Recommendation Report for Planning Permission for Works or Extension to a Dwelling

REF NO: FP/81/20/HH

LOCATION: 26 Links Avenue
Felpham
PO22 7BX

PROPOSAL: Installation of a dropped kerb/crossover.

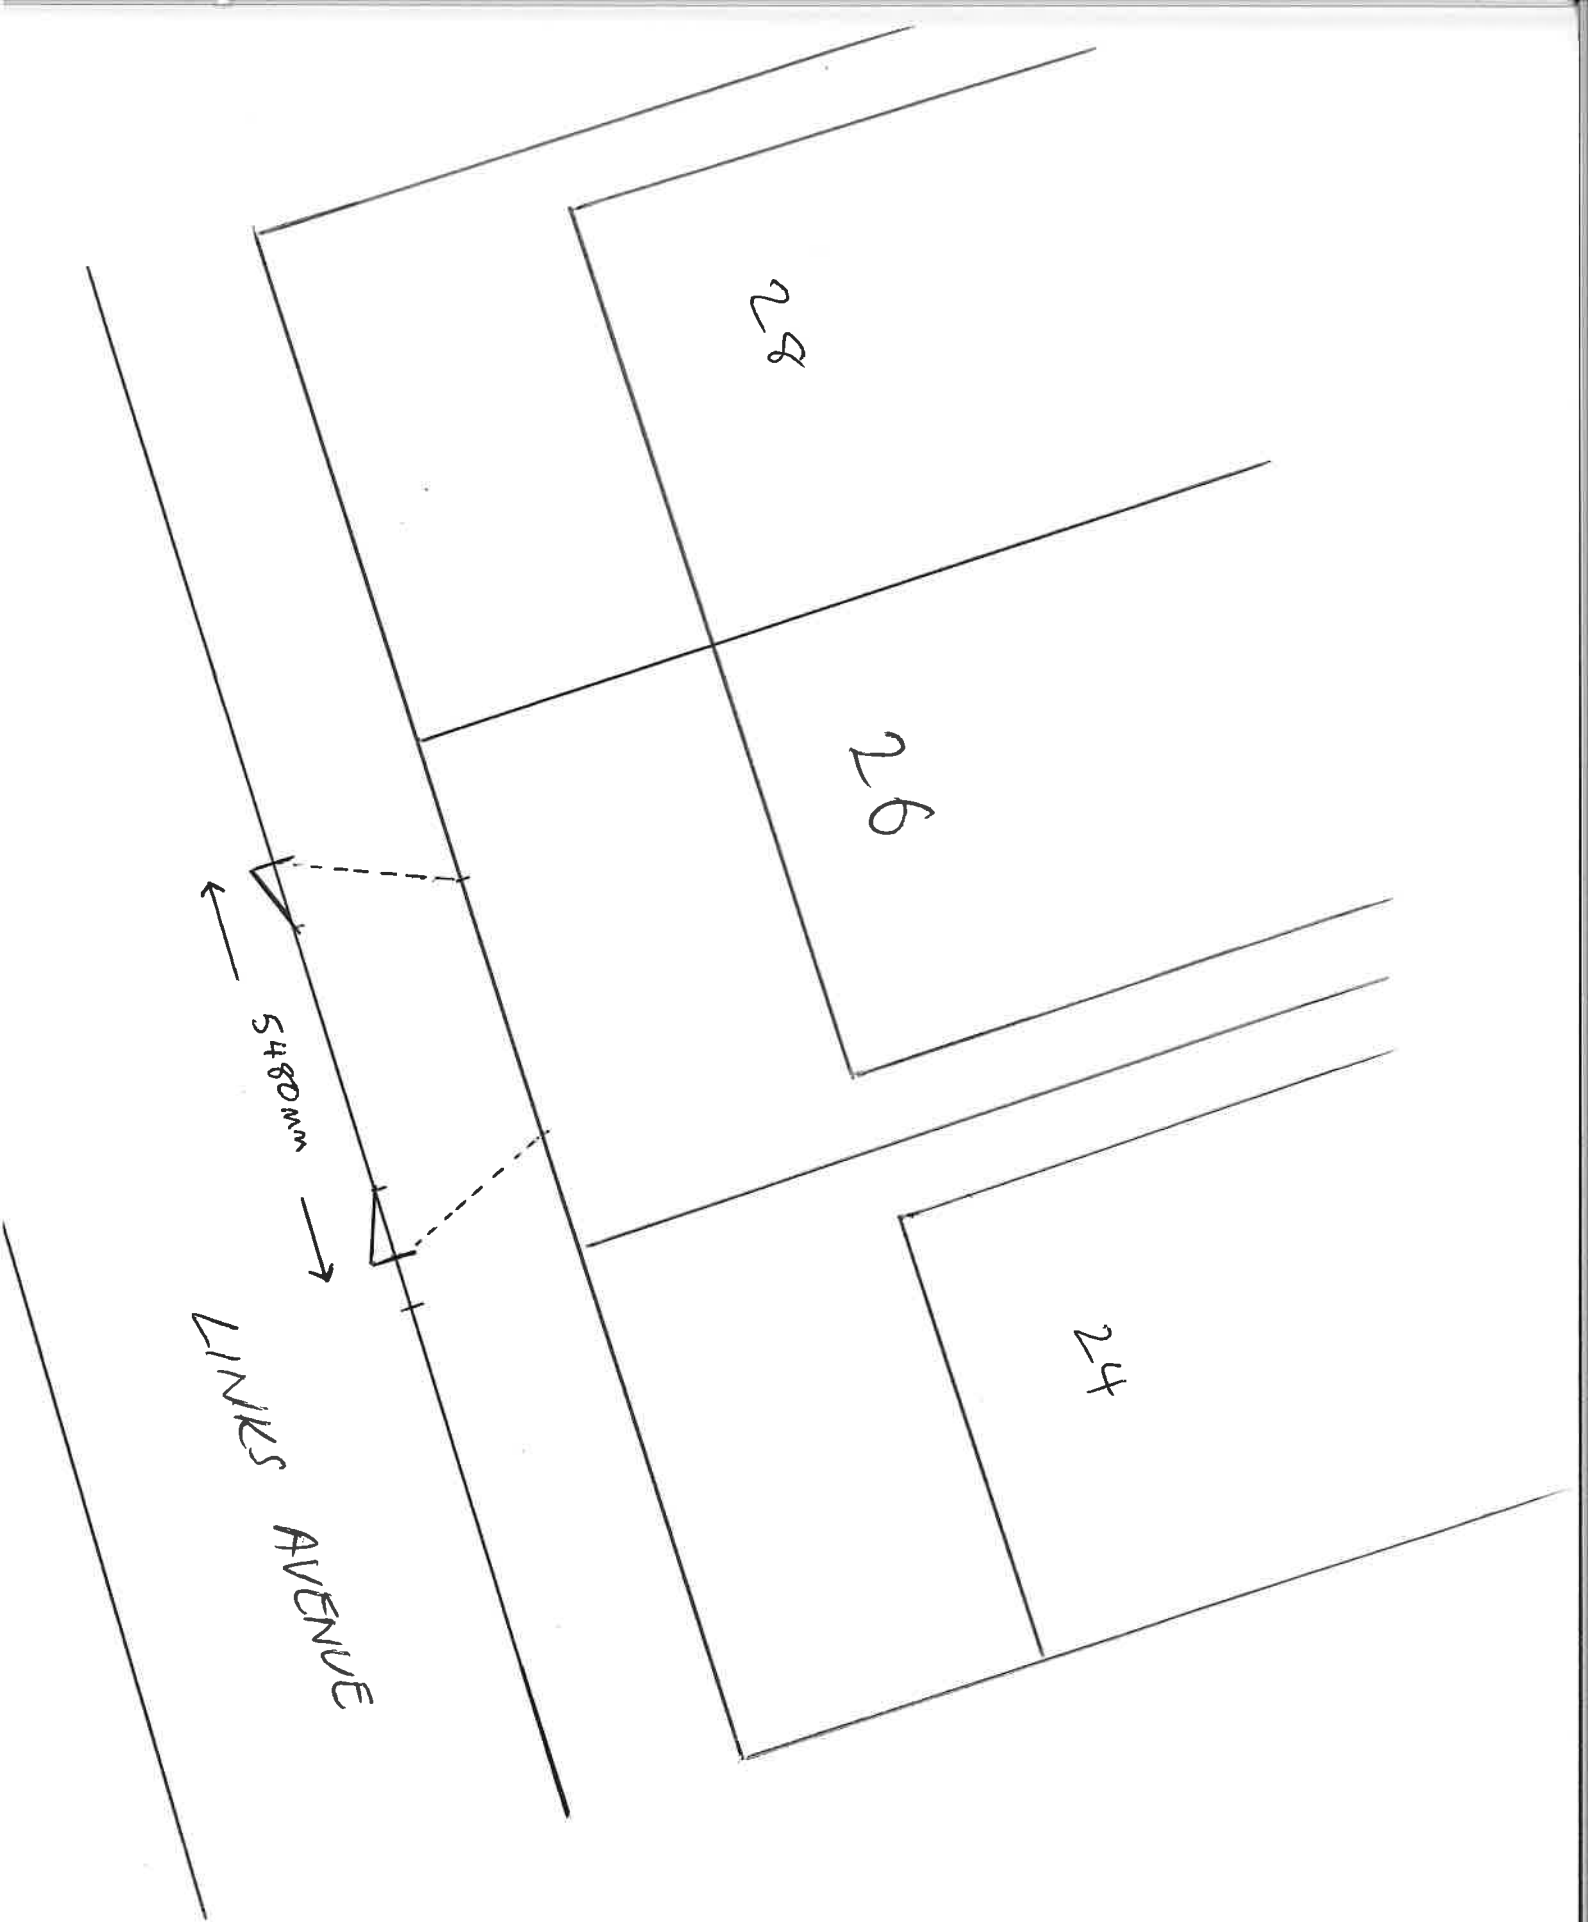
- Requested additional information relating to the width of the dropped kerb access and the dimensions of the parking area.

The LHA observes that the new parking area would not be practically accessible due to the location of the Crossover, the LHA therefore advise the applicant to modify the VCO to ensure that a vehicle can access without fouling upon the kerb. In principle the LHA does not consider a severe impact upon the highway.

An additional plan as received to increase the width of the dropped kerb for easier access to 5.4m.
